Consultation Response from KC, Lead Local Flood Authority
2024/93036 Greenside Mills, Saville Road, Skelmanthorpe, Huddersfield, HD8 9EE
Discharge of details reserved by condition 17 (drainage) of previous outline permission 2018/91787 for demolition of existing buildings and structures and erection of residential development
Date Responded: 11th April 2025 Responding Officer: Paul Farndale Responding Ref: 3

Condition 17 – Drainage Details

DRAWING No: ALT170724-202-01

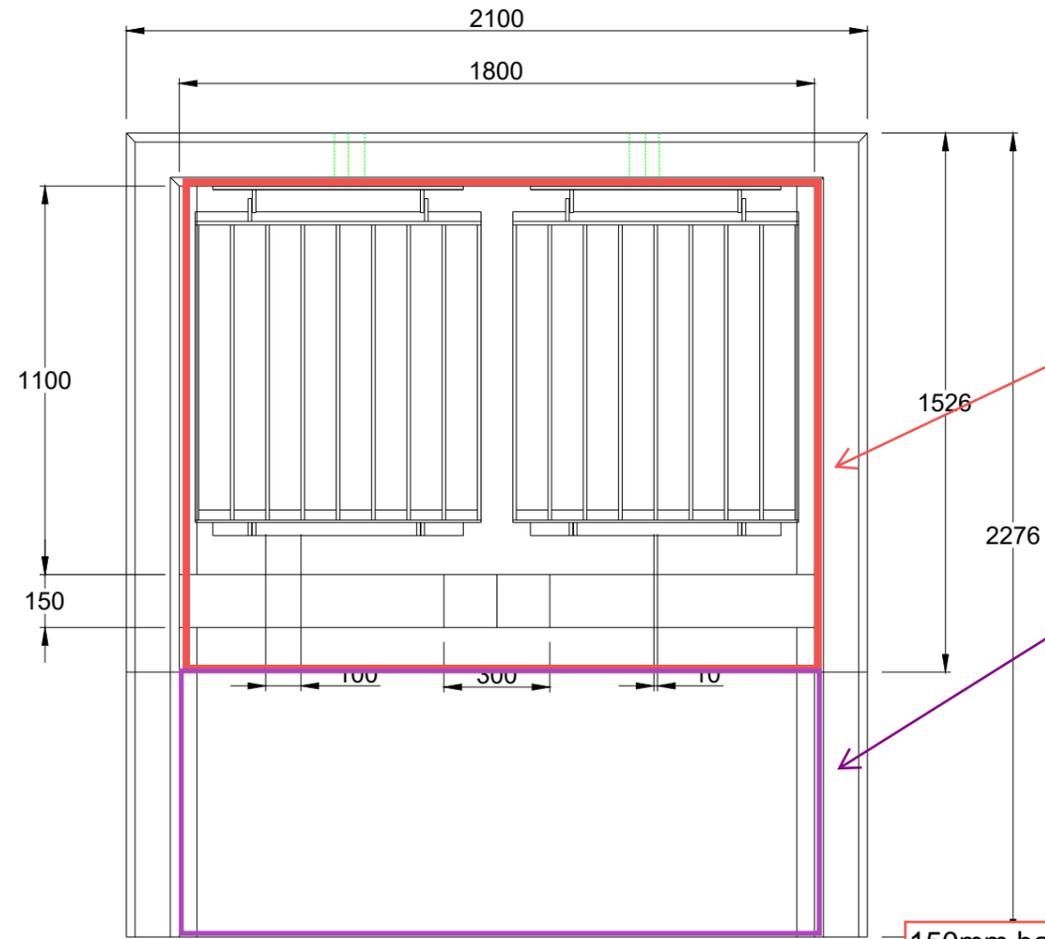
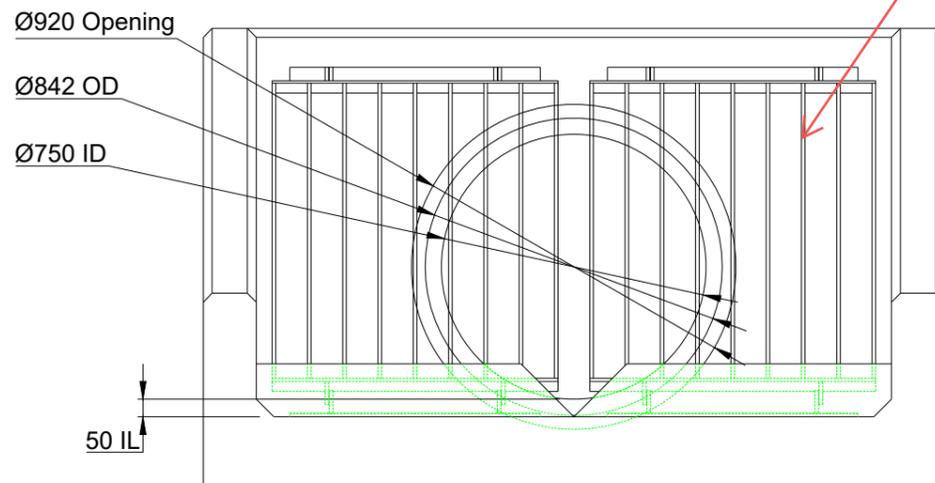
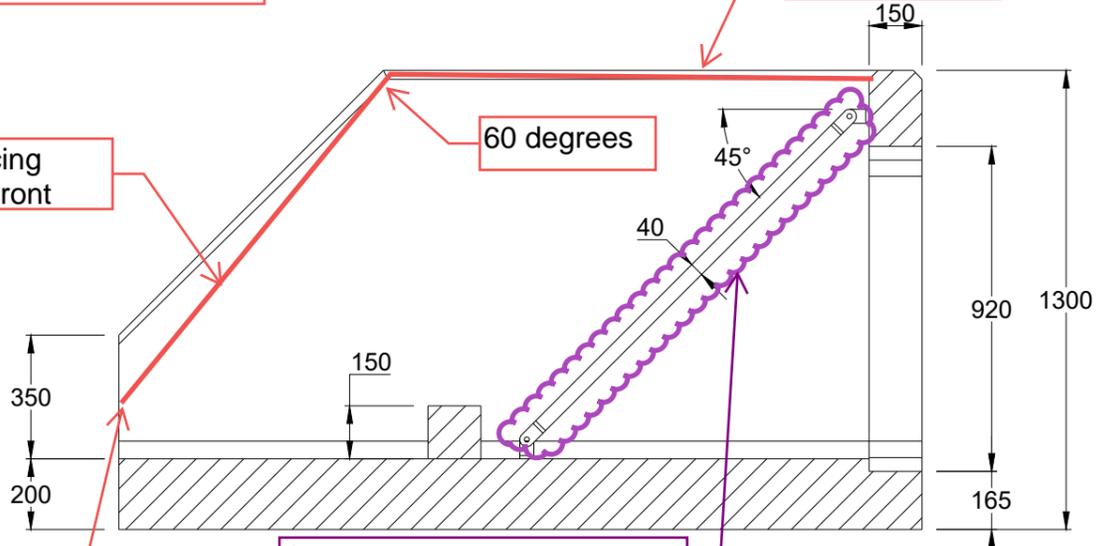
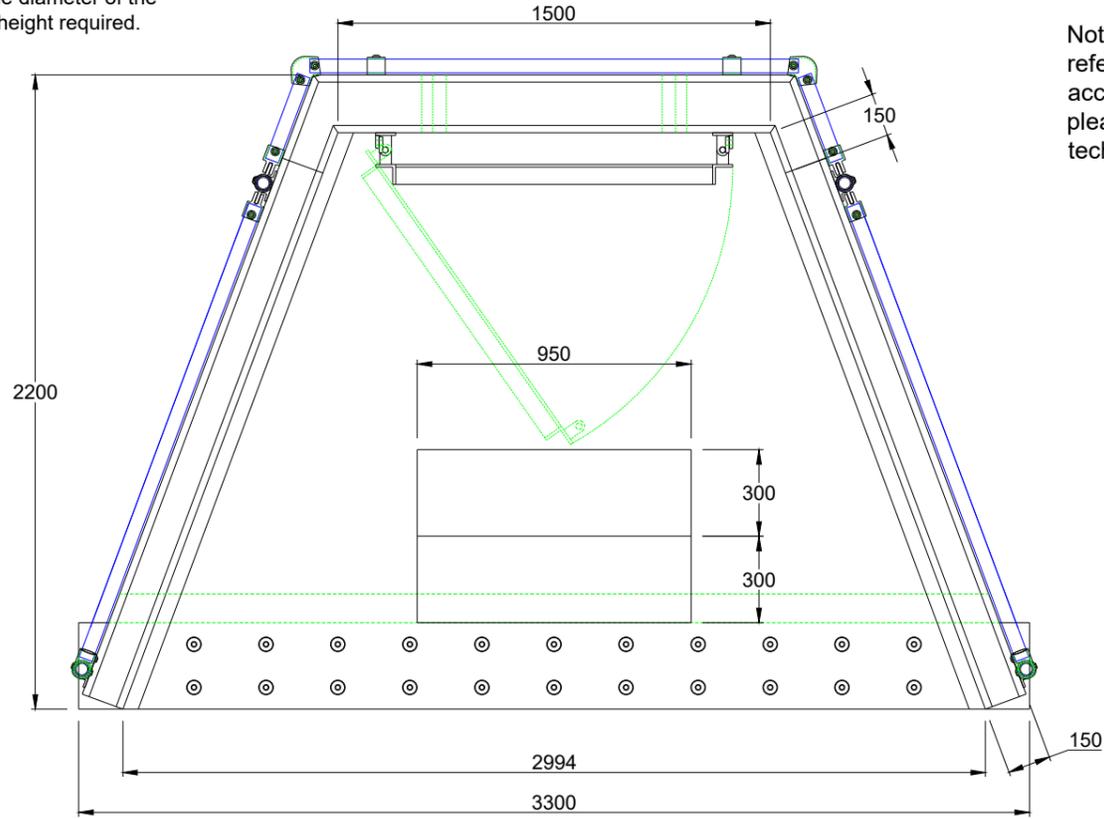
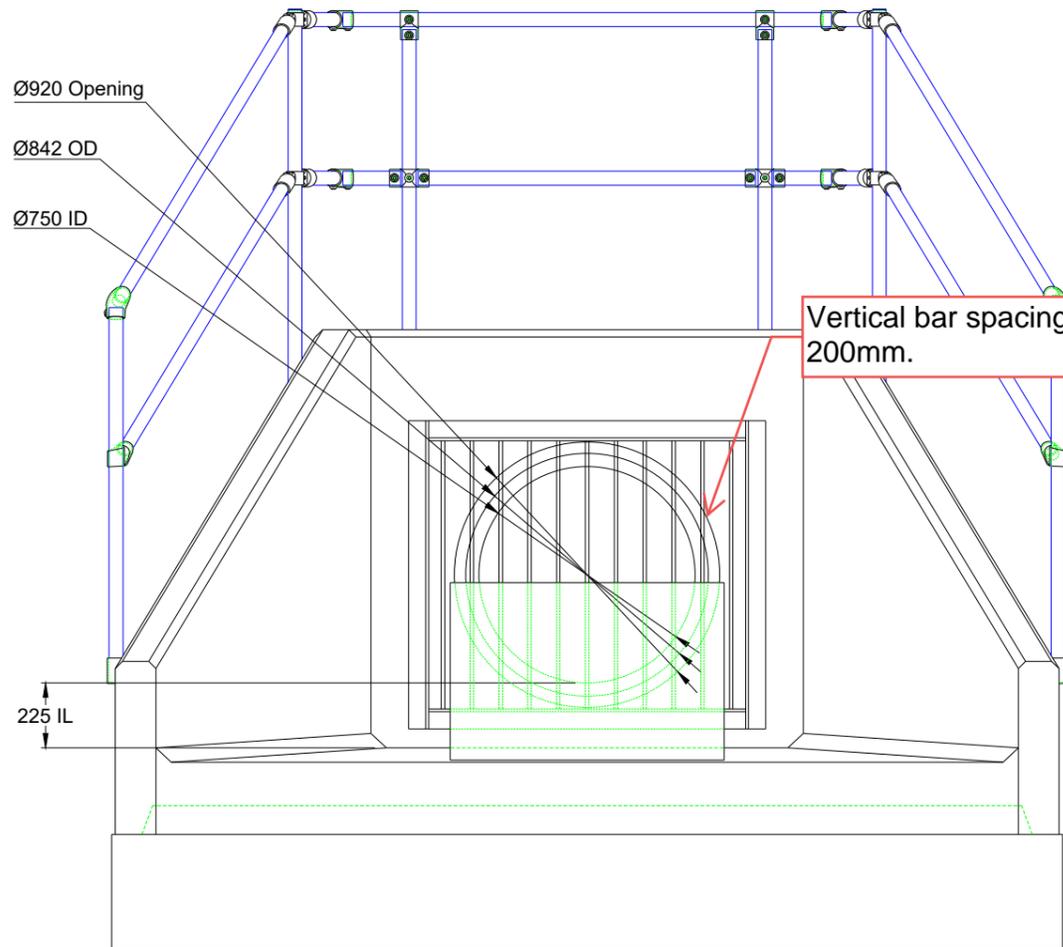
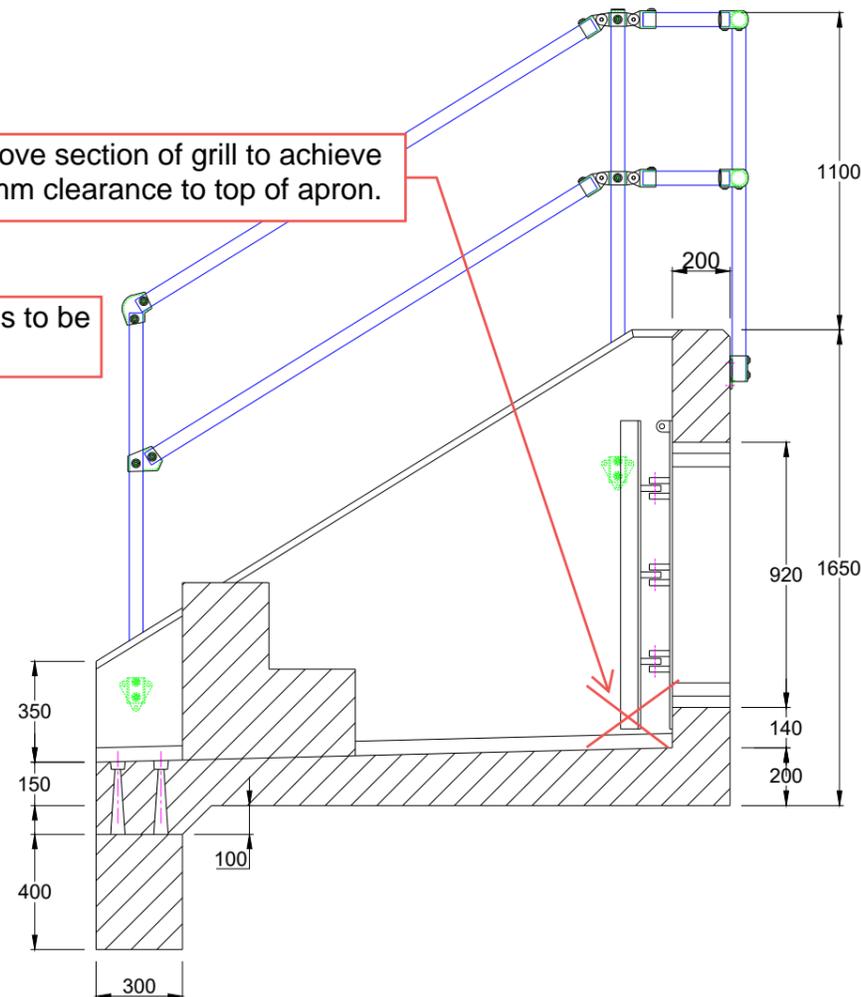
The submission of the revised Drainage Detail Calculations dated 5th March 2025 by Dudleys, includes updates to trash screen design this is now acceptable.

We can recommend that this condition can now be discharged.
